About the application

Application number: 2024/91594	
What is the application for?:	Erection of single storey side and rear extensions
Address of the site or building:	1, Dryclough Avenue, Crosland Moor, Huddersfield, HD4 5JU
Postcode:	HD4 5JU

User comments

Proposed Plans and Elevations

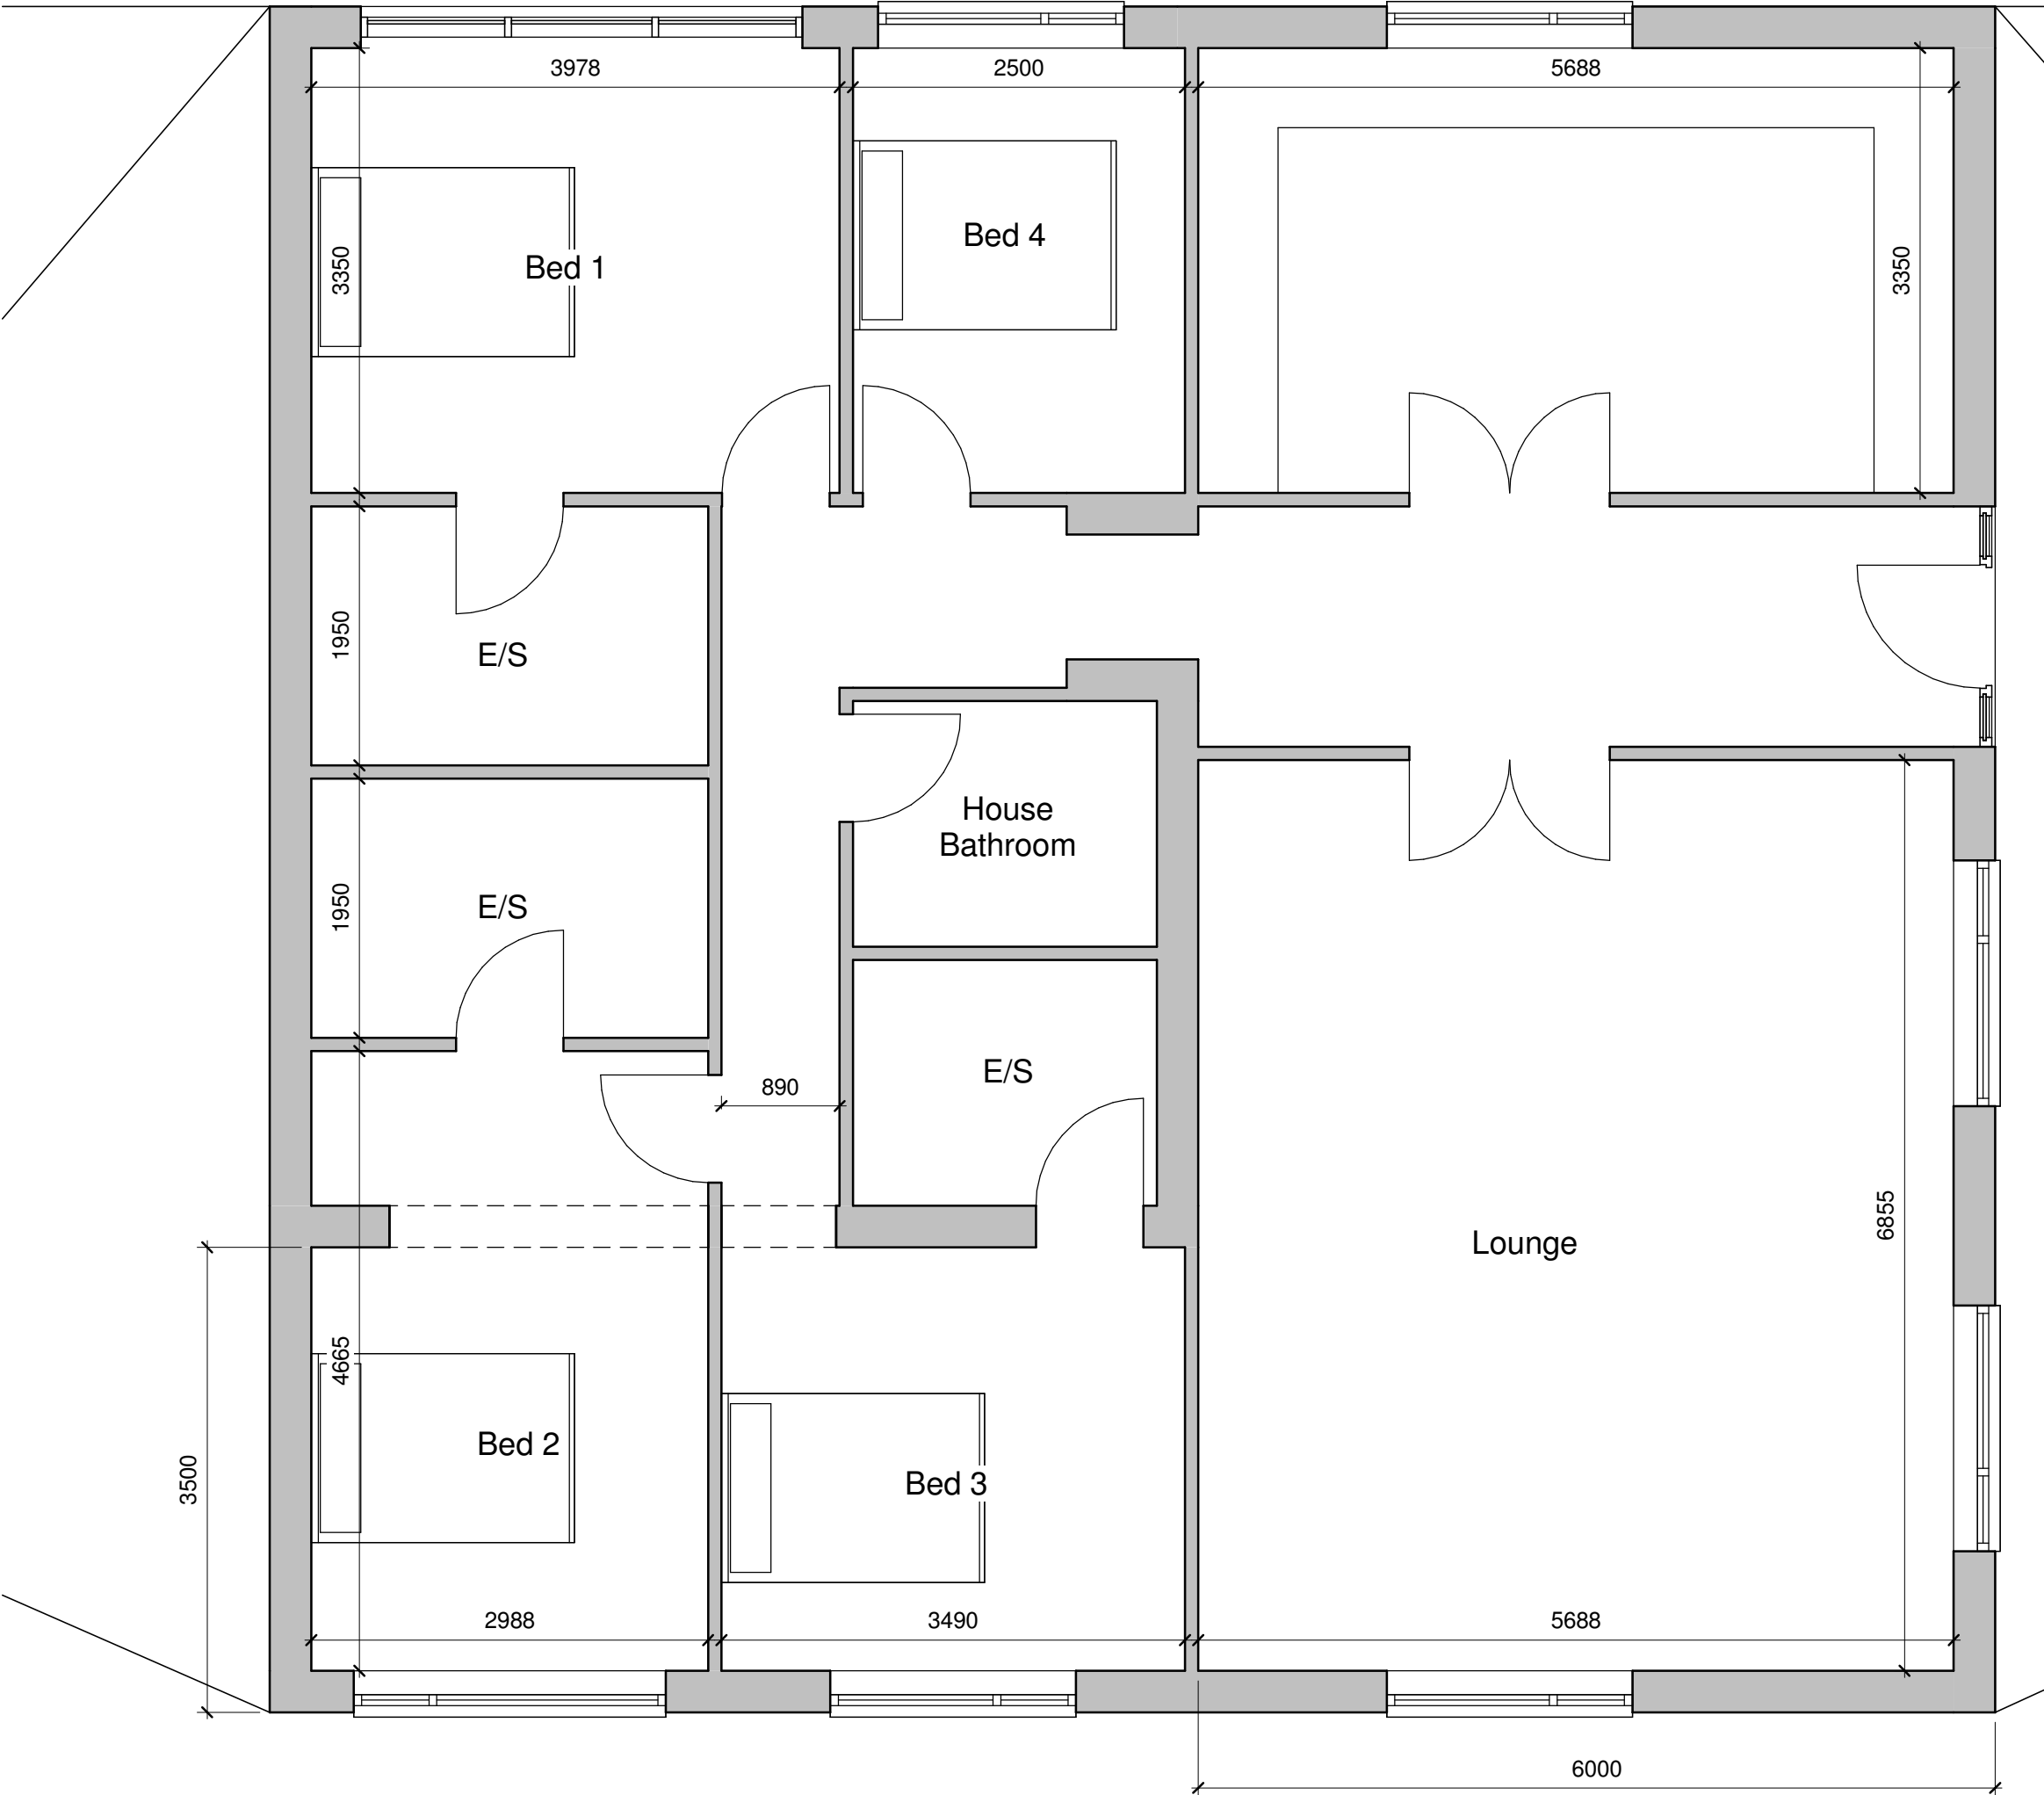
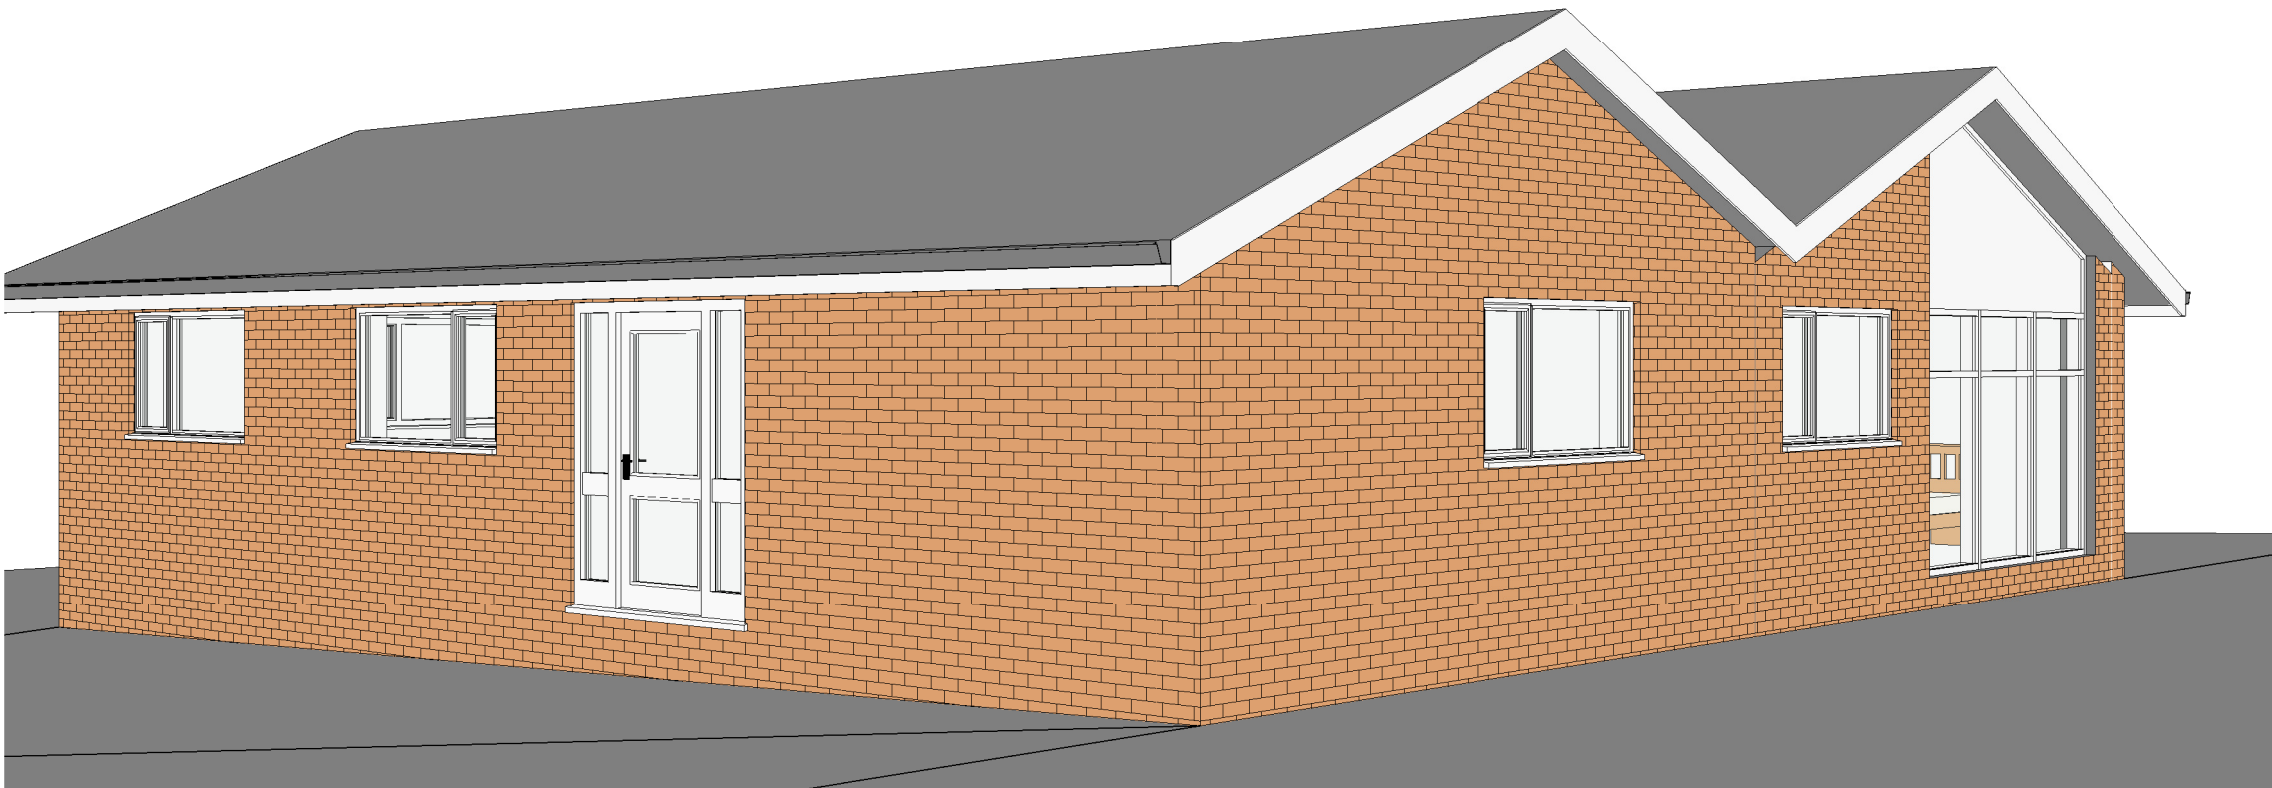
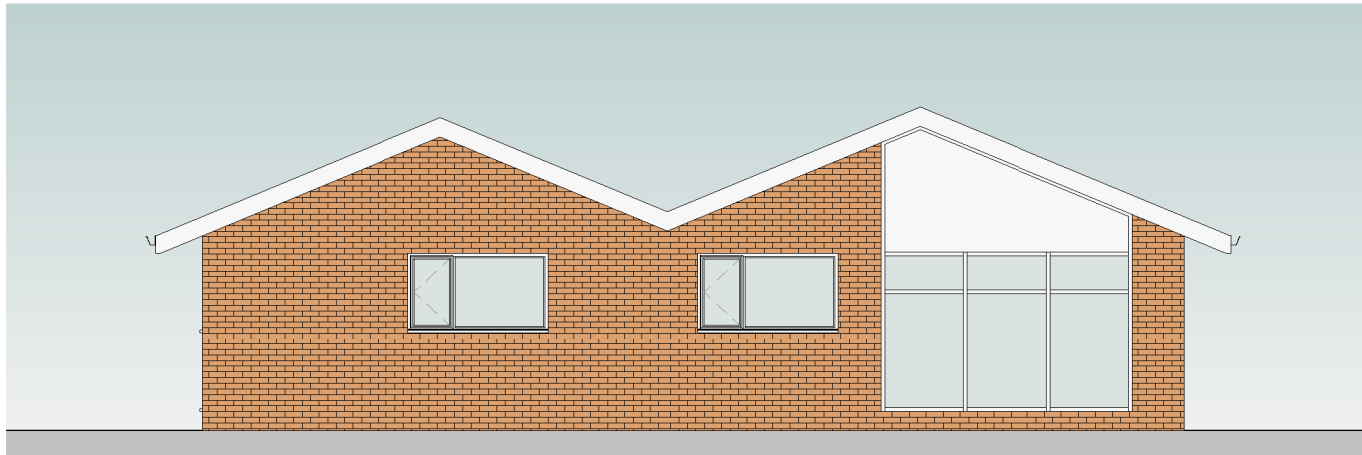
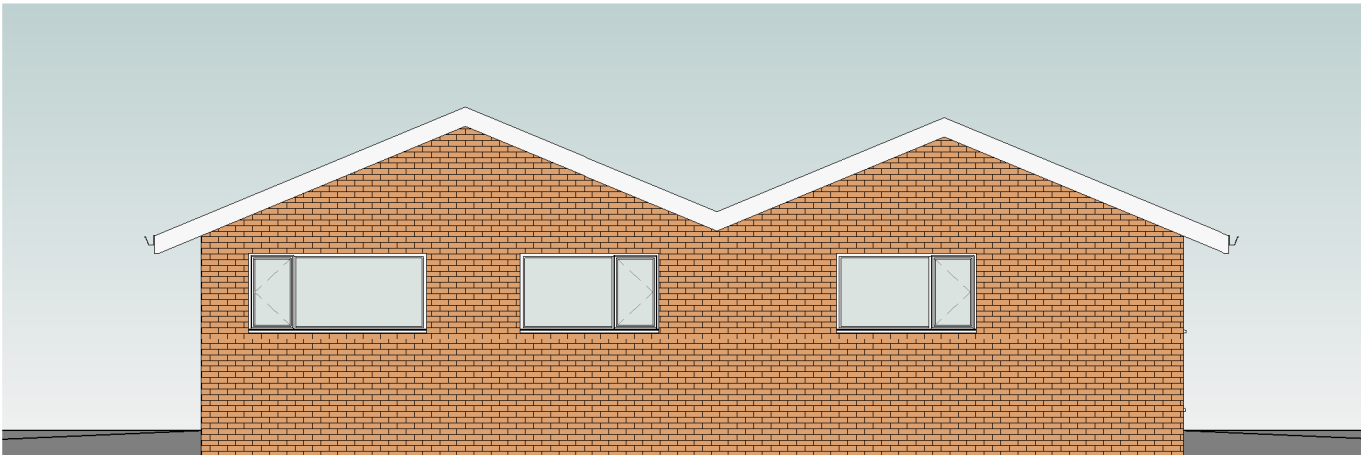
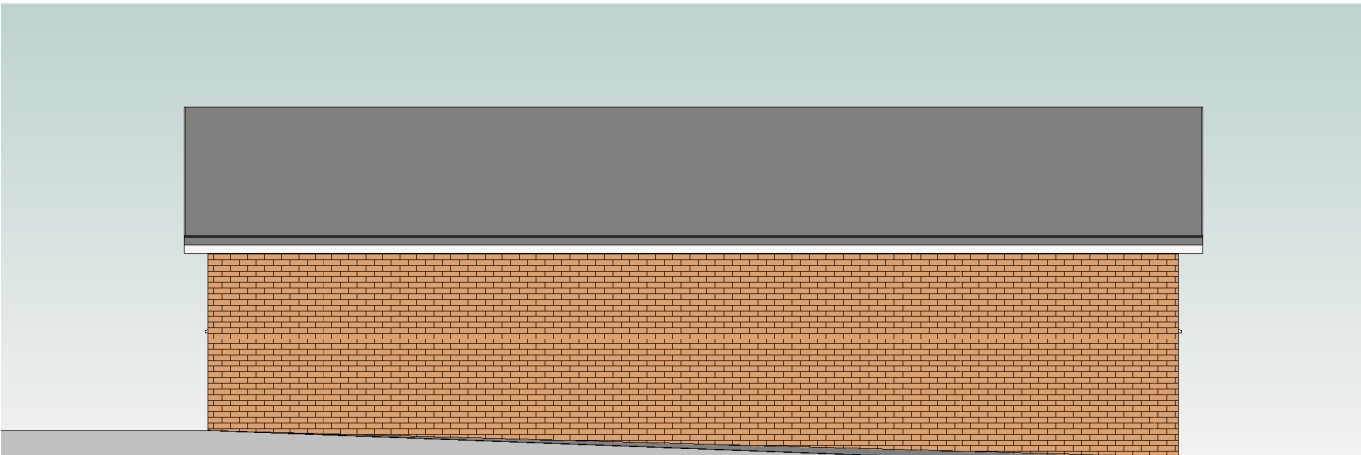
Type of comment: An objection	
Do you wish your comments to be published on the website anonymously?	Yes
I trust that the objections below will be those that are raised by Kirklees planning dept. but for the record - Design/appearance - While the proposed alteration to the front (west) elevation is in outline a mirror image of the existing, it would constitute a completely different/unprecedented frontage to the rest of the dwellings in the avenue. Character- The dwellings within the avenue are all set back from their front boundary by variously 4 - 15 metres. No.1 is already the bungalow that is sited closest to its boundary at 4 metres. The proposed extension to the north elevation would take it to about 1.5 metre. Highway safety - It would appear that the dwelling would continue to be let, possibly as an HMO, therefore further vehicles aligned to the property would constitute an exacerbation of existing erratic parking on this narrow street.
